ARUN DISTRICT COUNCIL

HISTORIC BUILDINGS ADVISOR CONSULTATION RESPONSE

Application Number: A/103/11 and A/104/11

Address: Pigeon House, High Street, Angmering

SITE PLAN & STREET ELEVATION AS PROPOSED

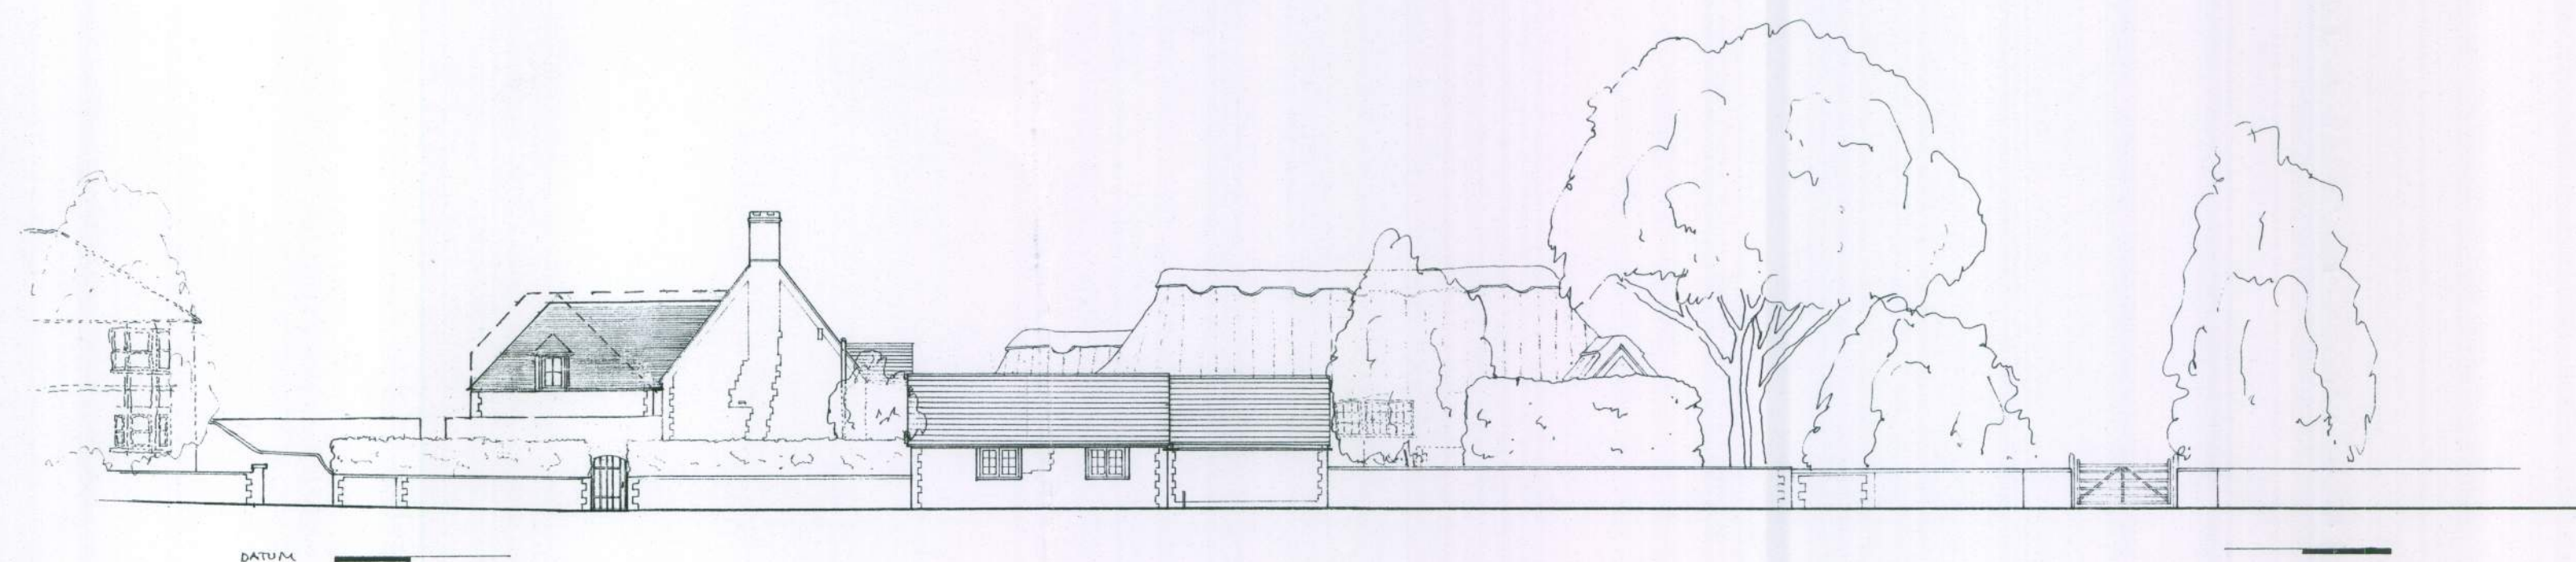
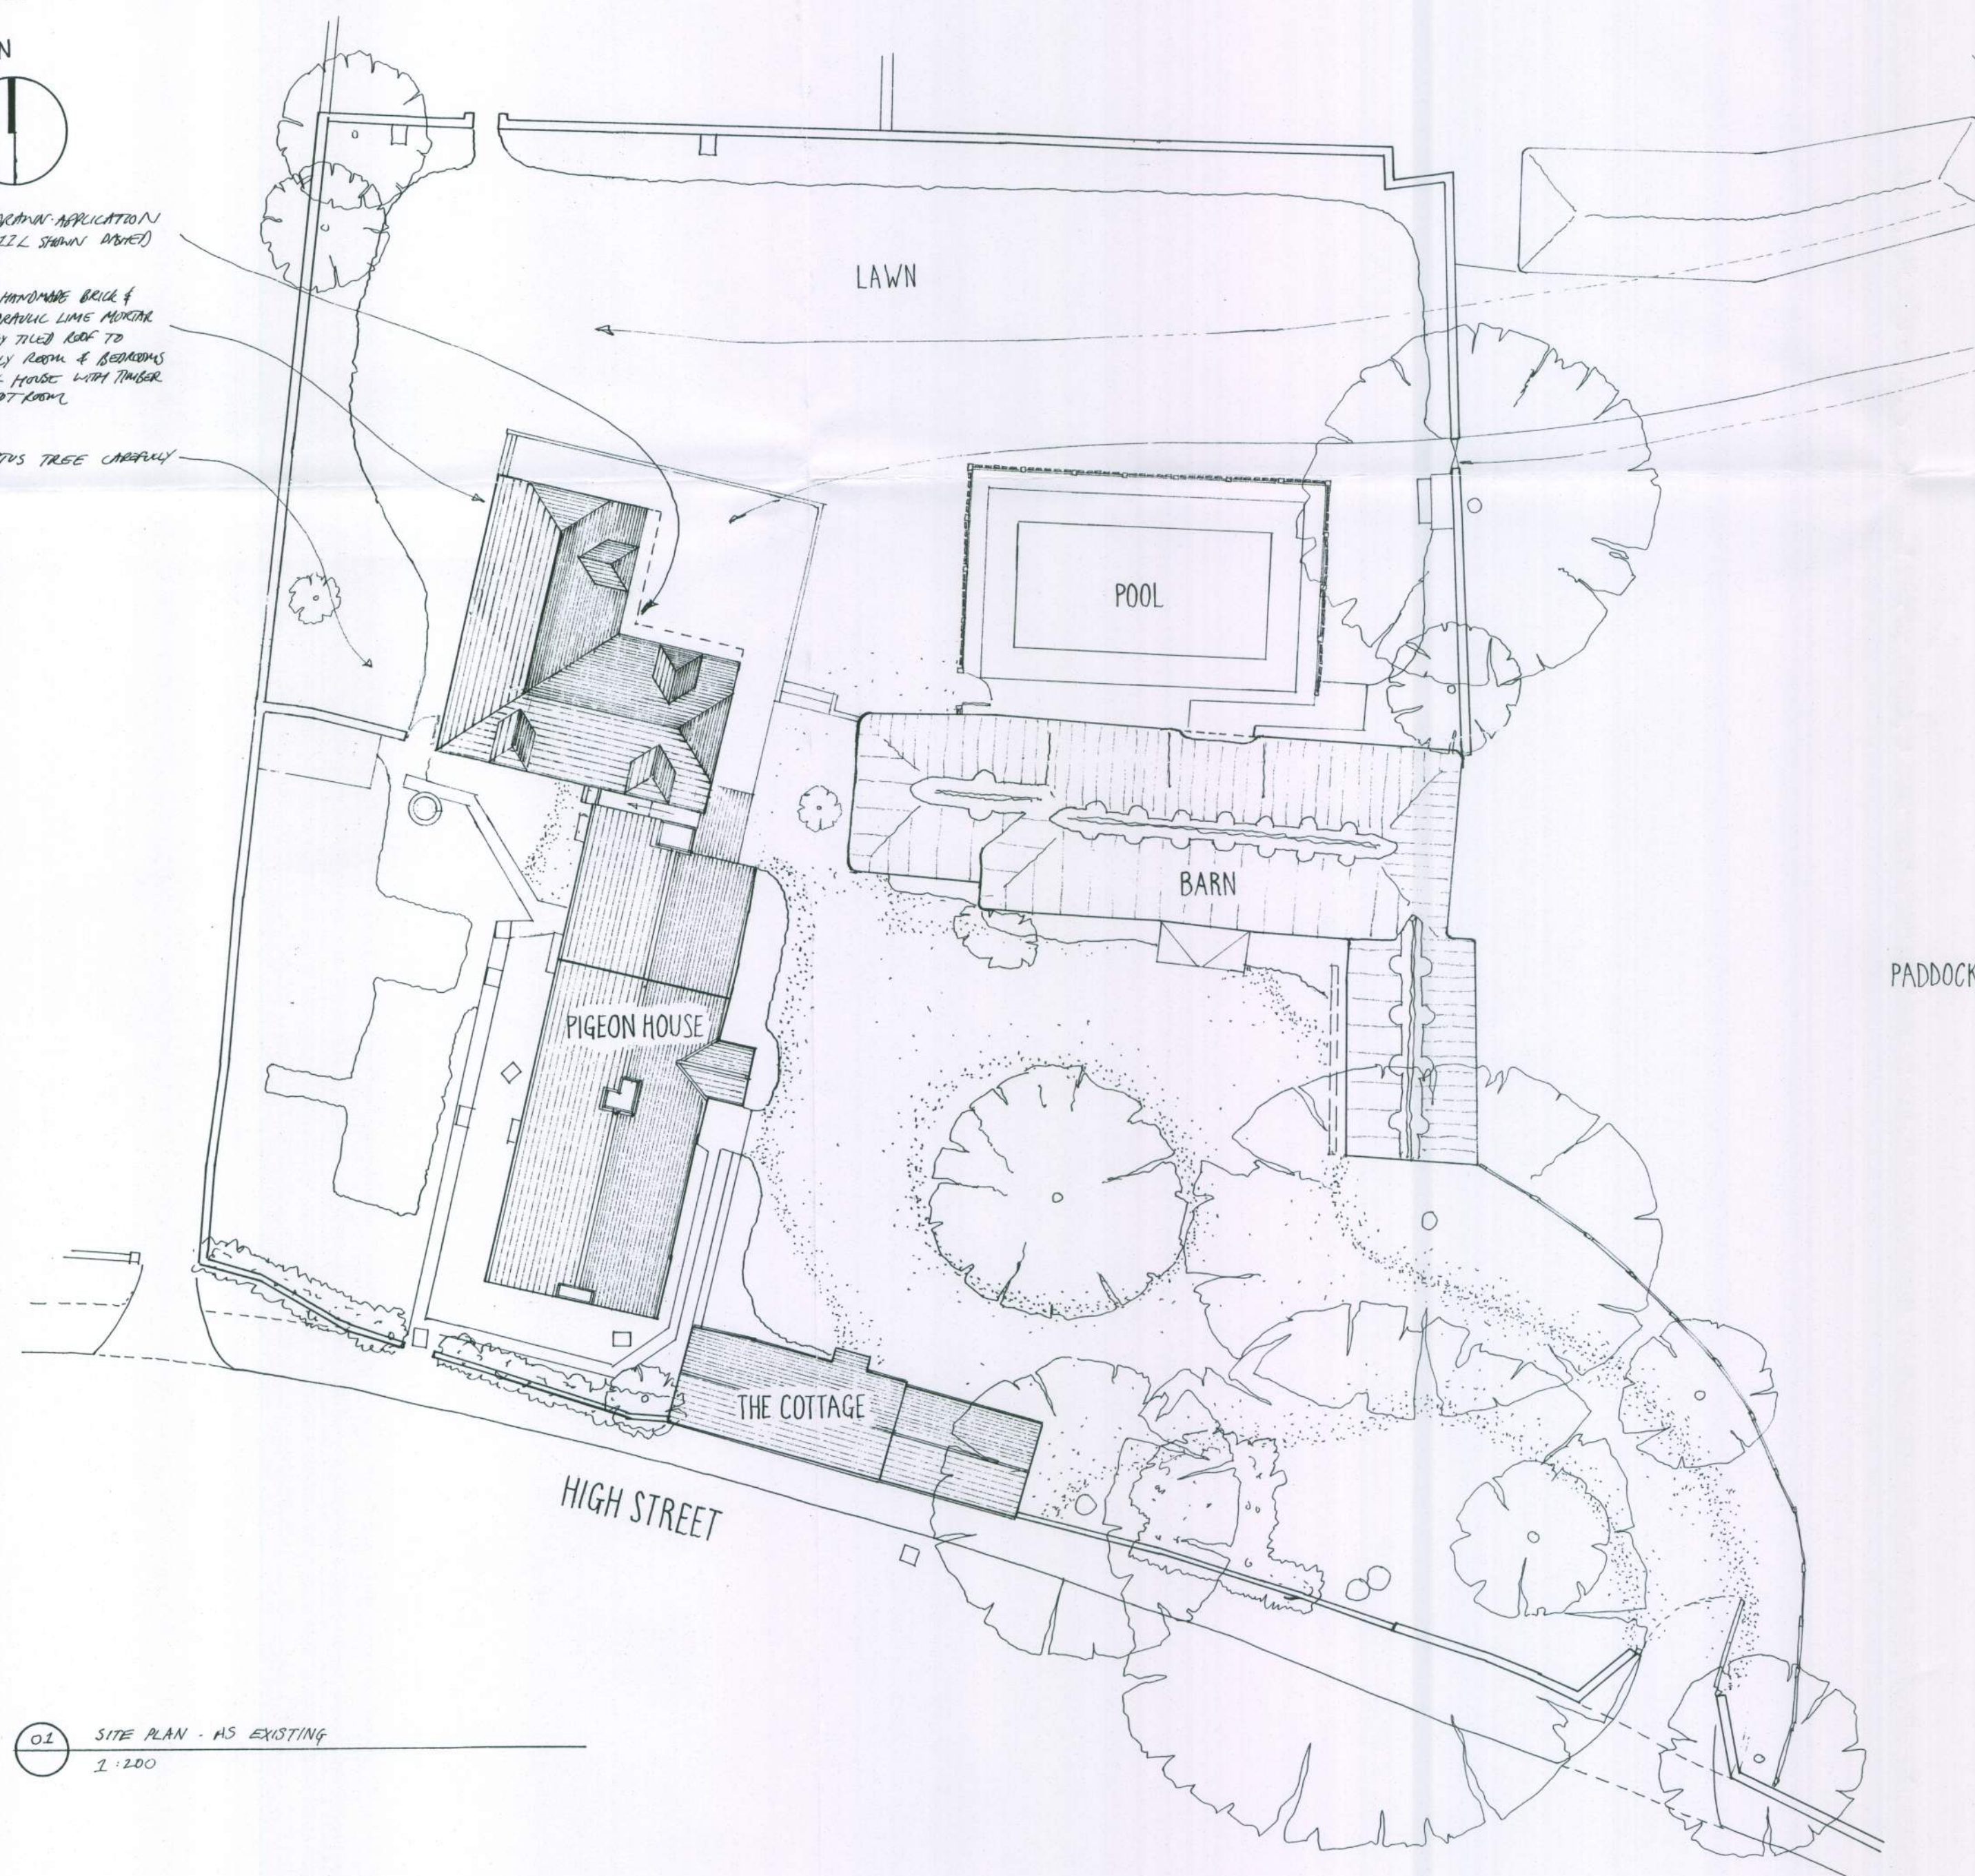
Unfortunately, the proposed building does not engage particularly well with this group or space. Viewed from the entrance, the space between the main house and the barn is obscured, whilst the building form itself is overly complex and a potential 'modern' distraction. Perhaps most damaging, is the issue that the building has the appearance of a separate dwelling and is not appropriately subservient as a simple subsidiary addition. Its 'L' shape form and orientation away towards the north are also alien to the concept of the

courtyard and as such creates a distraction to it. This is likely to affect the appreciation of the heritage assets and their historic setting.

The position of the building also results in direct material impact on the garden wall which becomes absorbed into the fabric of the new building, whilst further elements of historic wall (which at the very least will have archaeological value), are cleared away to make way for the 'extension'. It should be noted that the attempted incorporation of historic walls into new structures is a risk and can result in loss or rebuilding.

FOR PLANNING & LISTED BUILDING CONSENT
PIGEON HOUSE, ANGMERING
SCALE: 1:50 @ A1 DRAWN: SEPT 2010 DWG: PGM-MH/0.05 C
AS PROPOSED : NORTH & SOUTH ELEVATIONS
MALCOLM SIMMONDS ARCHITECTS

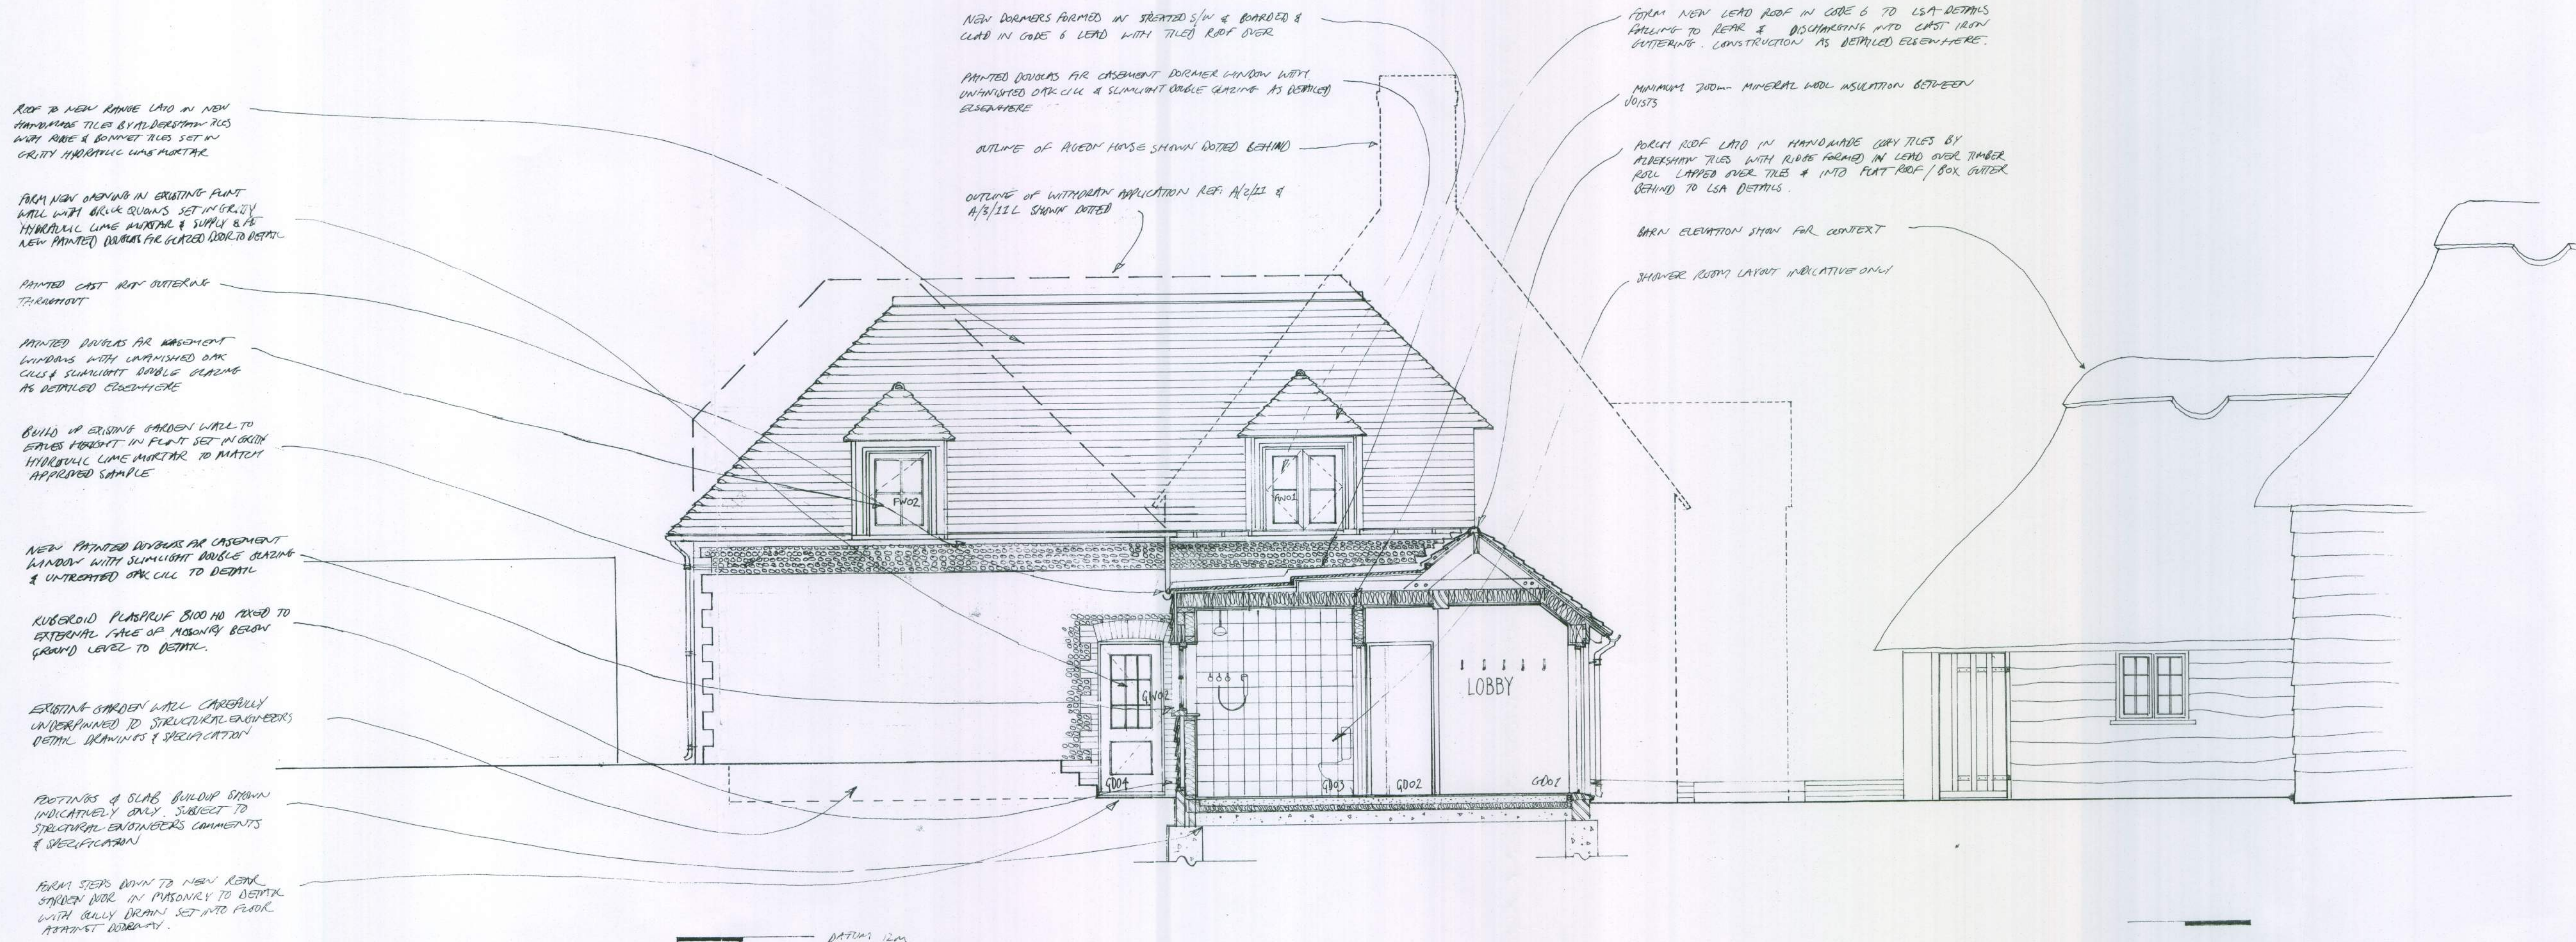
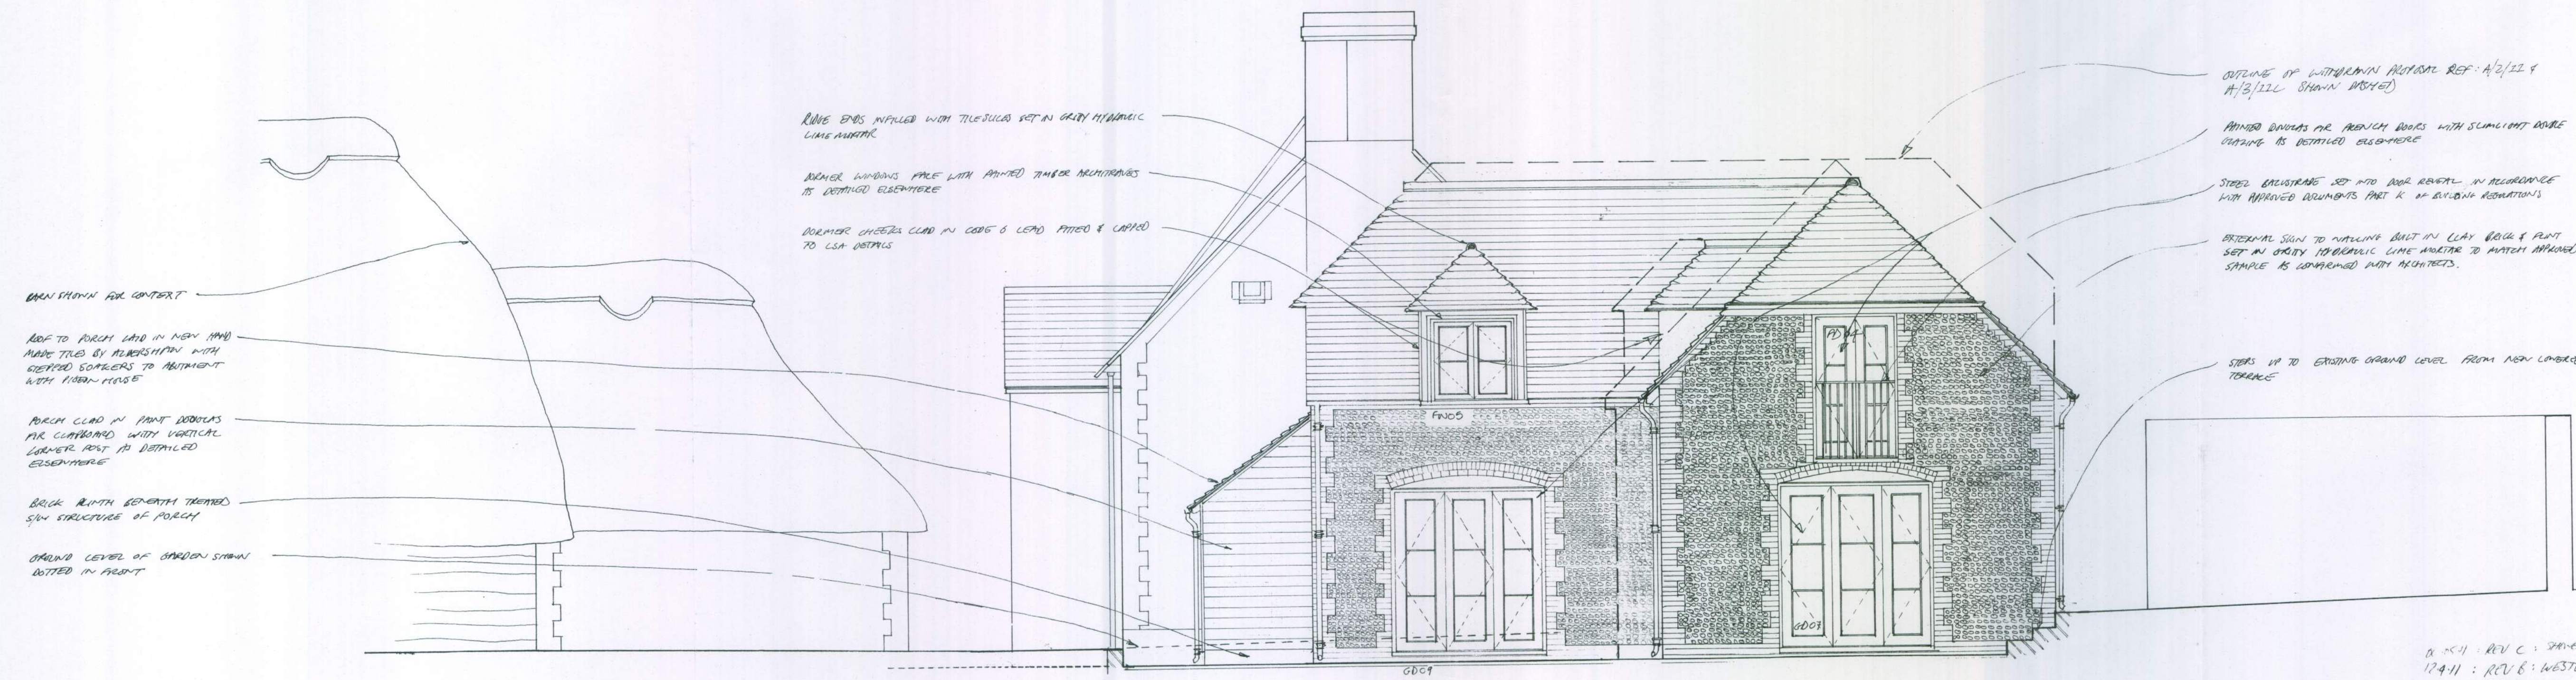
As well as the shape and orientation of the building, the scale, massing and material of the structure is also highly problematic. A two storey building here will have an impact on the appreciation of the listed house and its setting. Its height and scale certainly appears to compete with the house and the adjacent barn, particularly from the north and will be dominant from within the garden. It should be remembered here that the issue of 'setting' is not determined by public amenity, nor is it particularly limited. A number of issues, some of which are raised here, should be taken into account here and include:

The lack of subservience is further compounded by the proposed use of high flint and brick elevations. Given the building's scale, the use of masonry here only adds to the building's weight and impact. As such it is not materially subservient to the adjacent assets, particularly with the barn which is partially a soft structure.
